Response to Highways England Deadline 9 Document 8.93(a):

8.93(a) Actions Arising out of ISH on Compulsory Acquisition and Temporary Possession on 22 October for Deadline 8

(TR010027-000890-AS Highways England M42J6_8.93(a)_Actions_Arising_out_of_ISH_on_Compulsory_Aquisition_and_Temporary_Possession_on_22_Oct_for_Deadline)

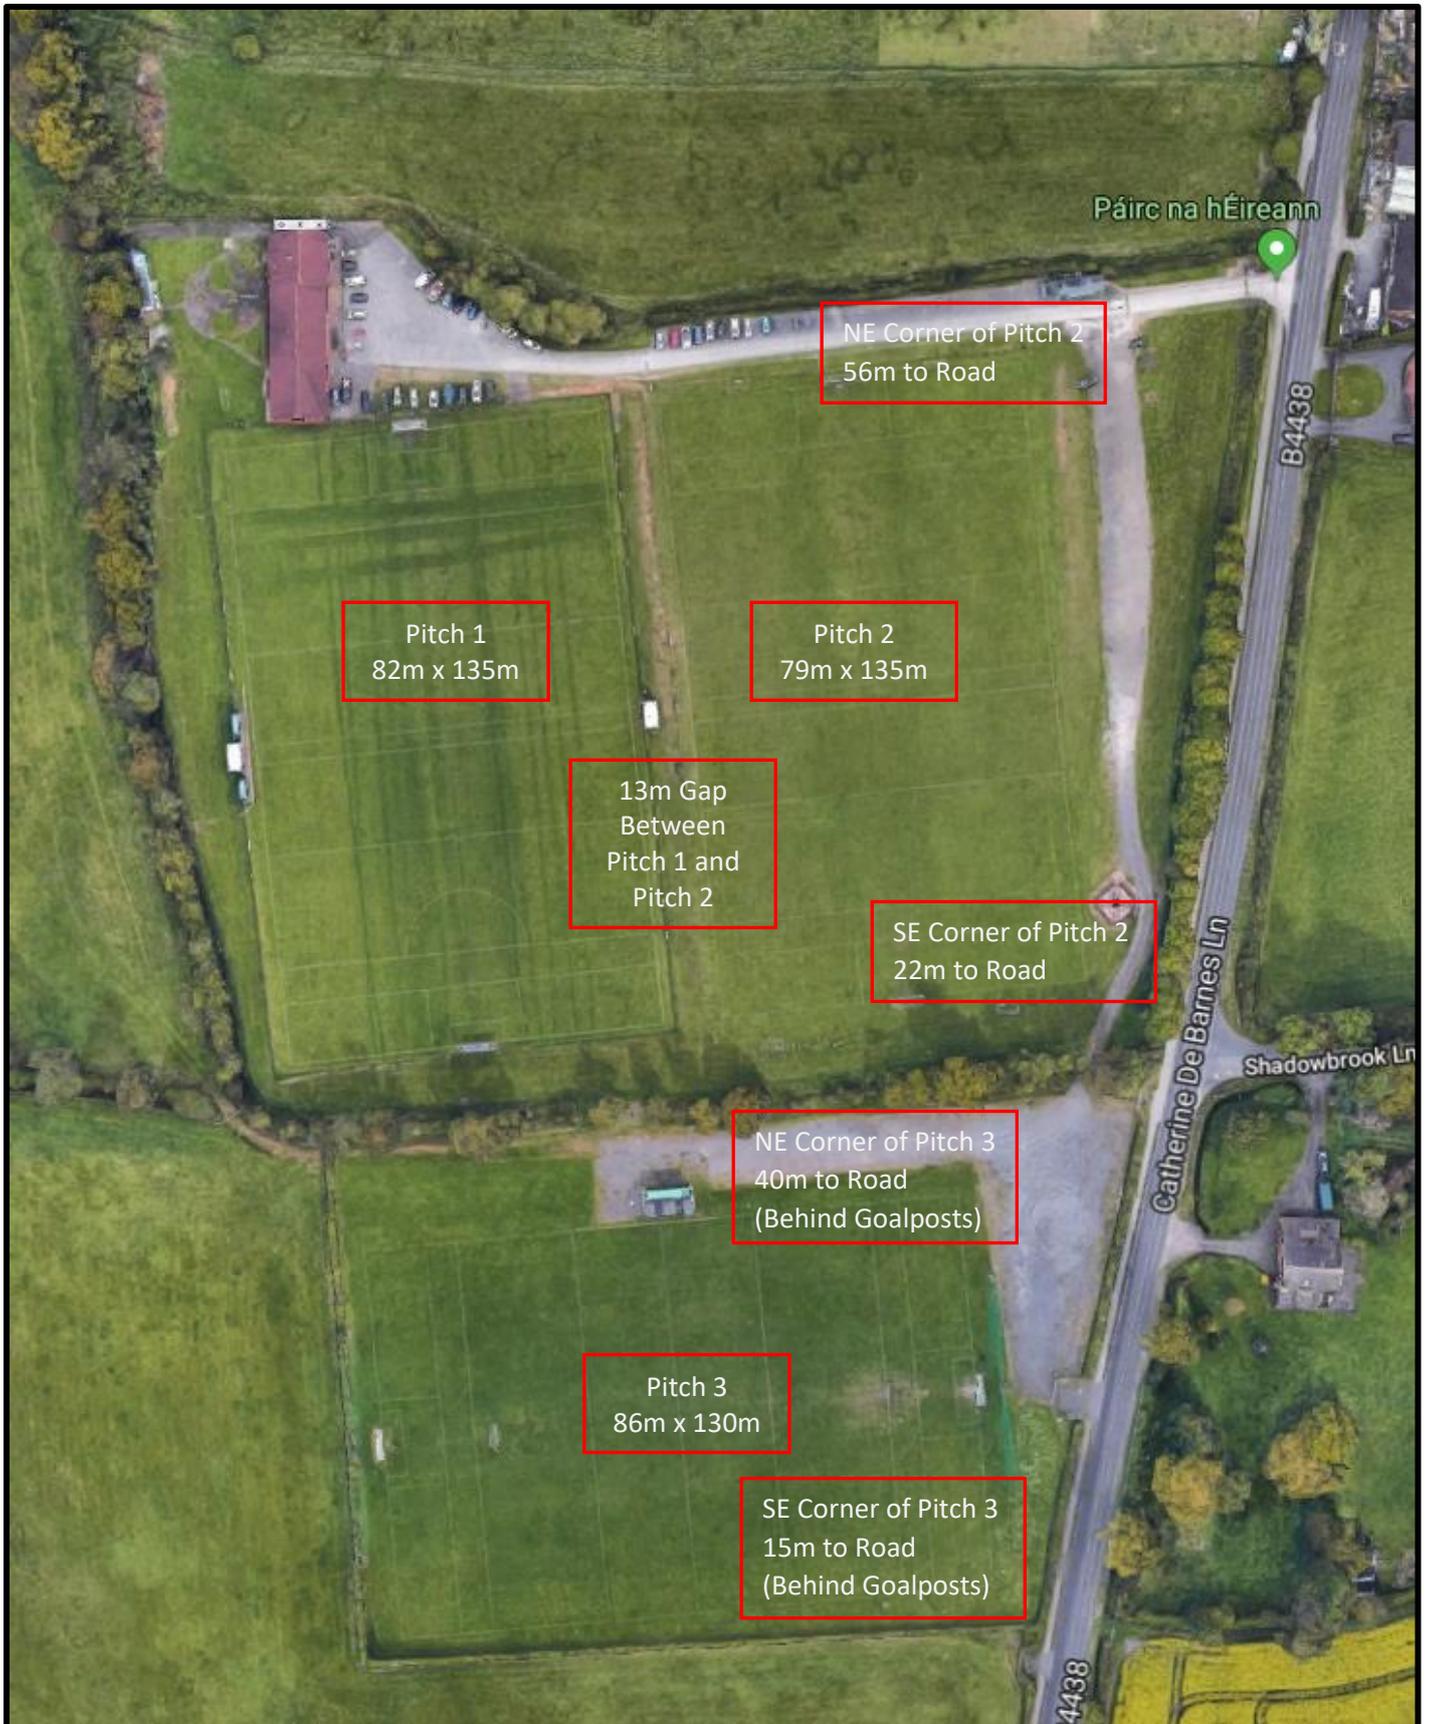
It is worth noting that HE are concerned that Option 3A will have a marked impact on Birmingham Dog's Home despite it being further from the Option 3A pitches than my property will be from either the 8.21 DCO Scheme or the WGAA 'Legacy Scheme' they are pursuing with the WGAA.

The table confirms that Option 3A has the highest score for:

- Programme 4 (4 is the highest)

The table confirms that Option 3A has the second highest score for:

- Location 3 (4 is the highest)
- Safety 3 (6 is the highest)
- Cost 2 (3 is the highest)
- Environment 4 (5 is the highest)

The table confirms that Option 3A has the lowest score for:

- Statutory 1 (3 is the highest)

However, Option 3A is a contiguous reconfiguration and has been given the same score as Options 1A, 1B, 1C and 1D which are full relocations. As such, this is likely to be a mistake and the correct score should be 2.

I would suggest it is clear from the above that Option 3A was a viable option that would satisfy all parties affected by the Scheme. Unfortunately, Highways England did not give it the consideration it required and it was dismissed without a full and proper assessment being carried out.
